Date: 01/20/2020
File No: 70583UTC
Property Address: Marksheffel Road South, Colorado Springs, CO 80925
Buyer\Borrower:
Seller: Glen Investment Group No. VIII, LLC, a Colorado limited liability company

COMMITMENT FOR TITLE INSURANCE
ISSUED BY
WESTCOR LAND TITLE INSURANCE COMPANY

The Glen at Widefield Subdivision Filing No. 11, County of El Paso, State of

THE GLEN AT WIDEFIELD SUBDIVISION FILING NO.11

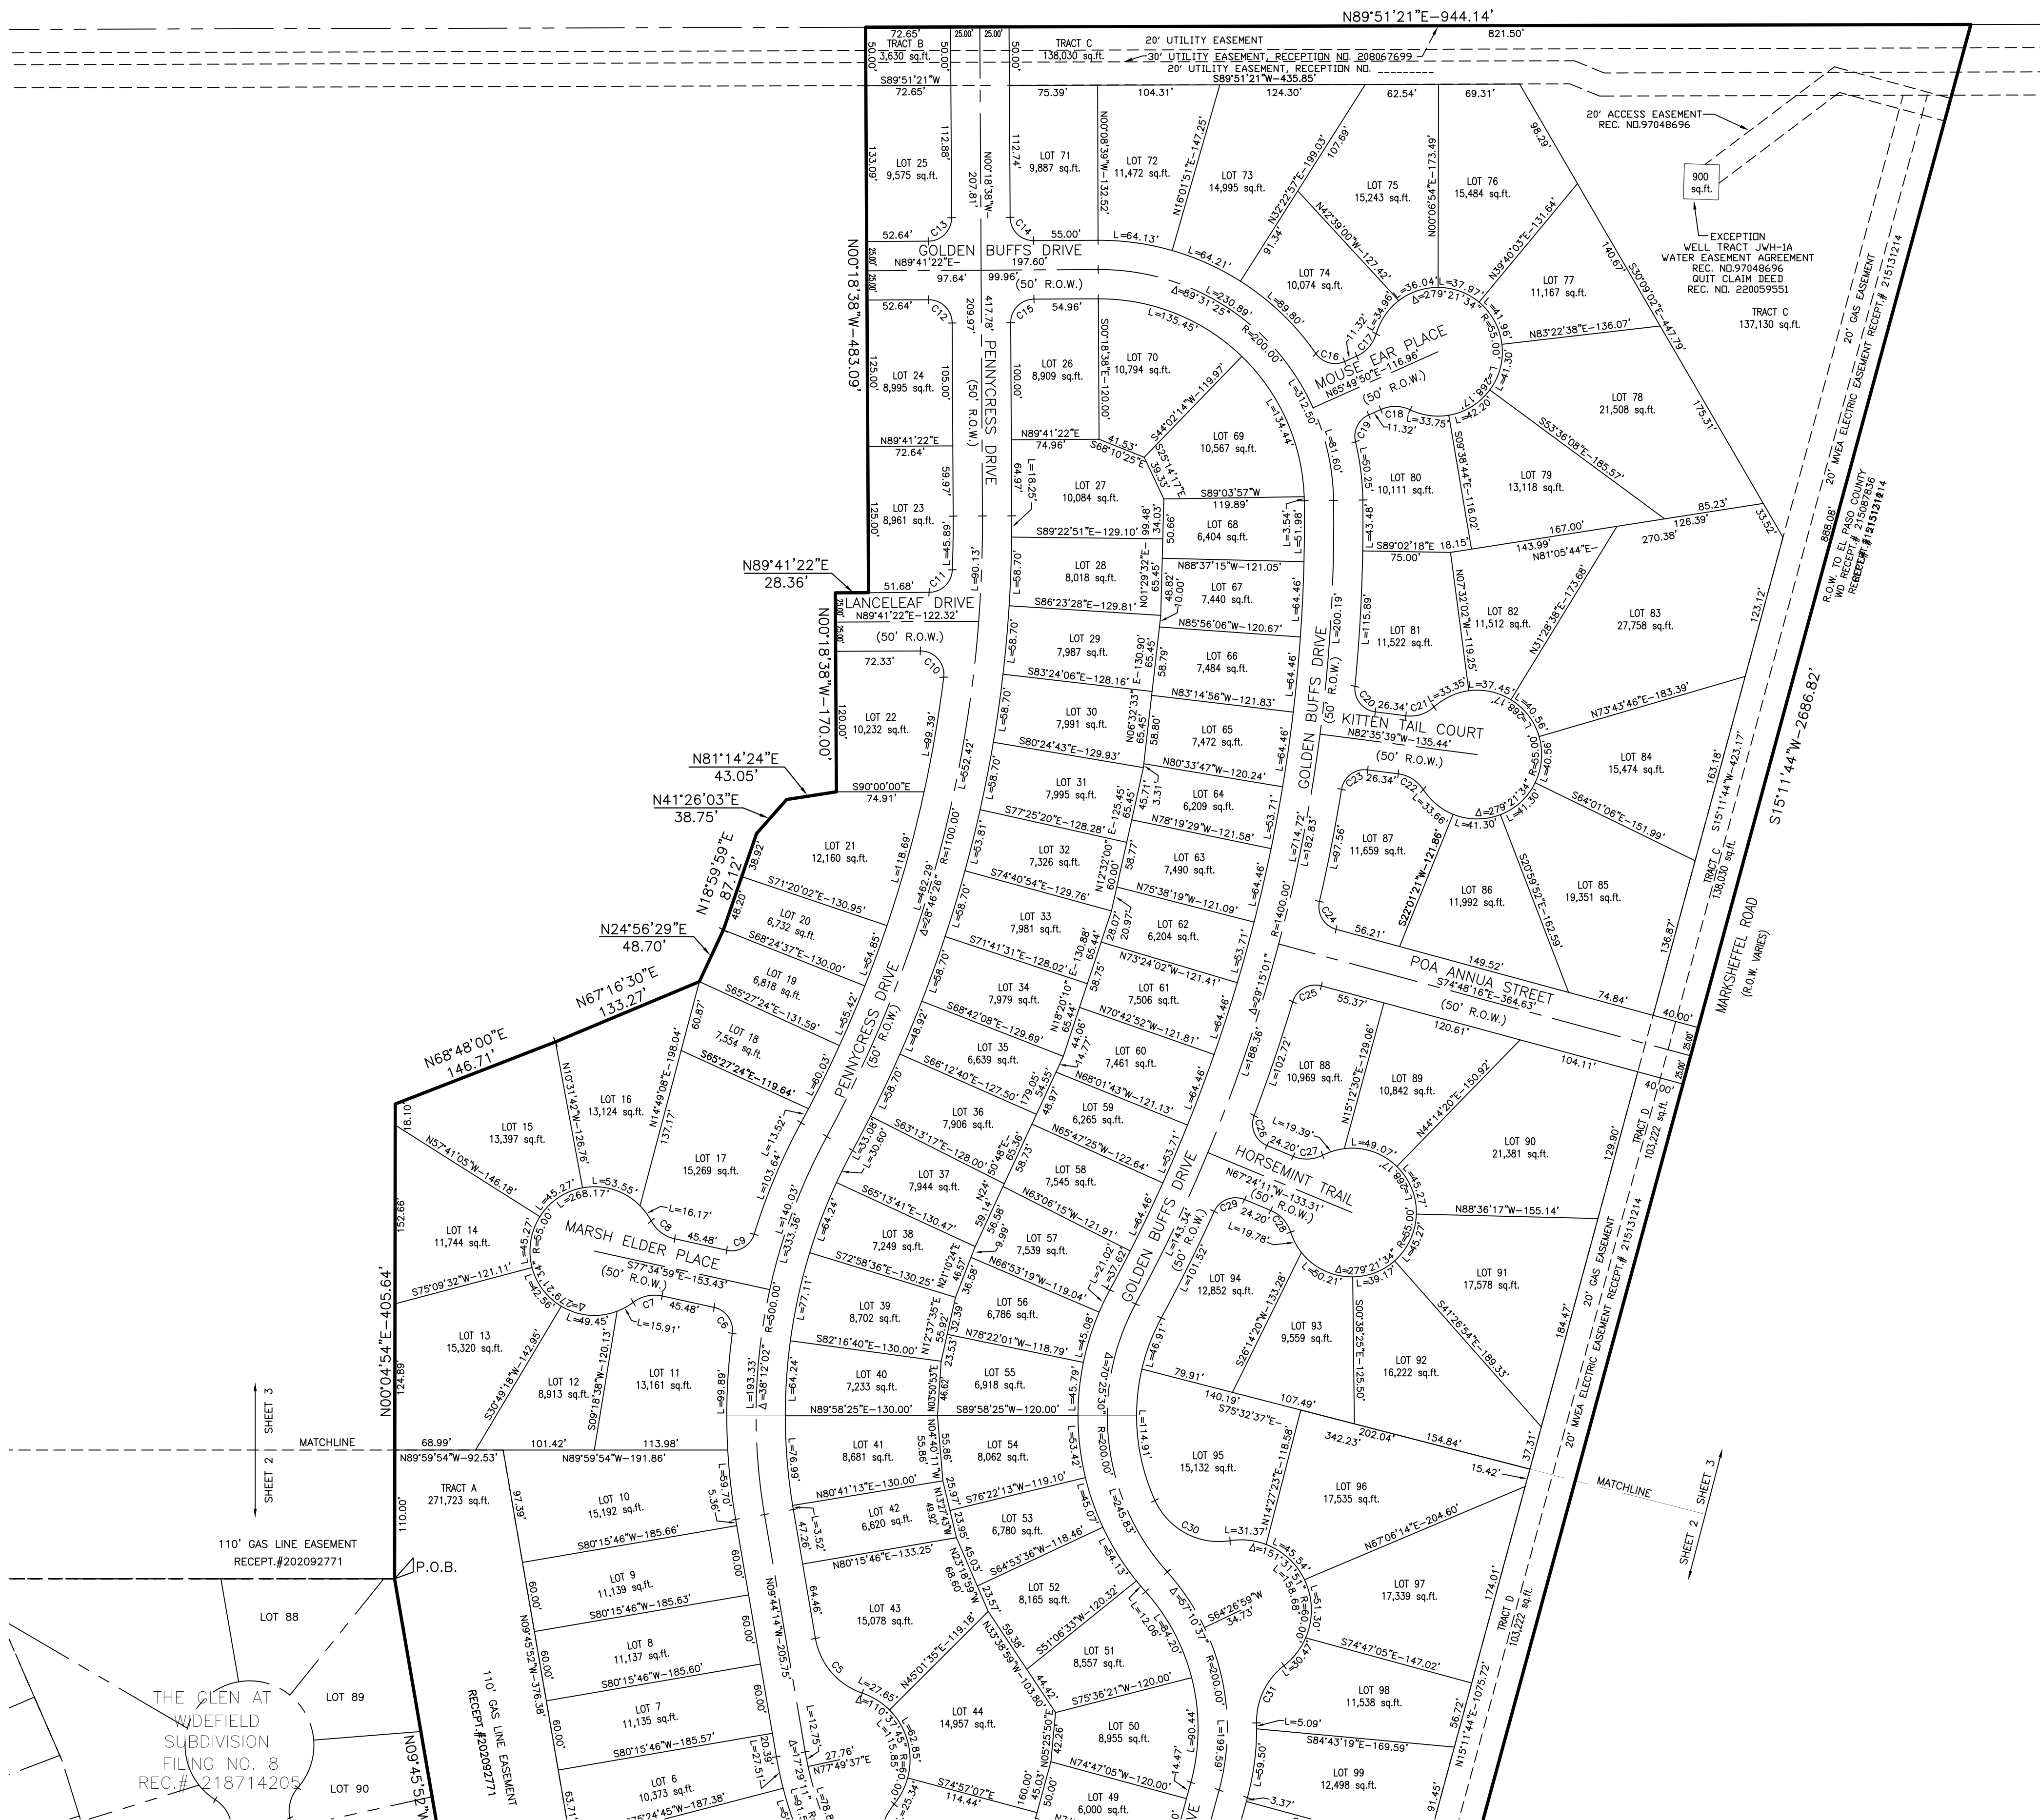
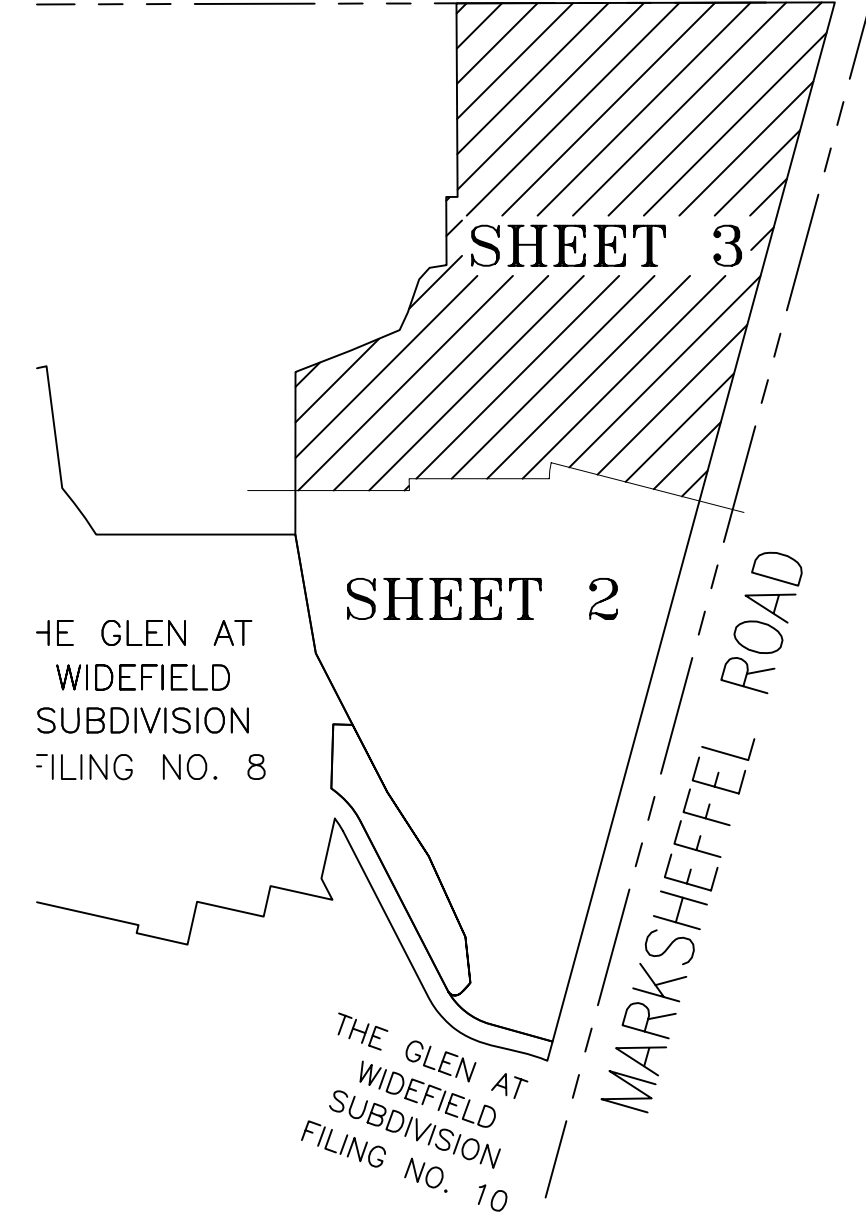
Provide clarification as to why the legal for the well sites are not included on plat, but are within the legal of the Title to be platted as Filing 11.
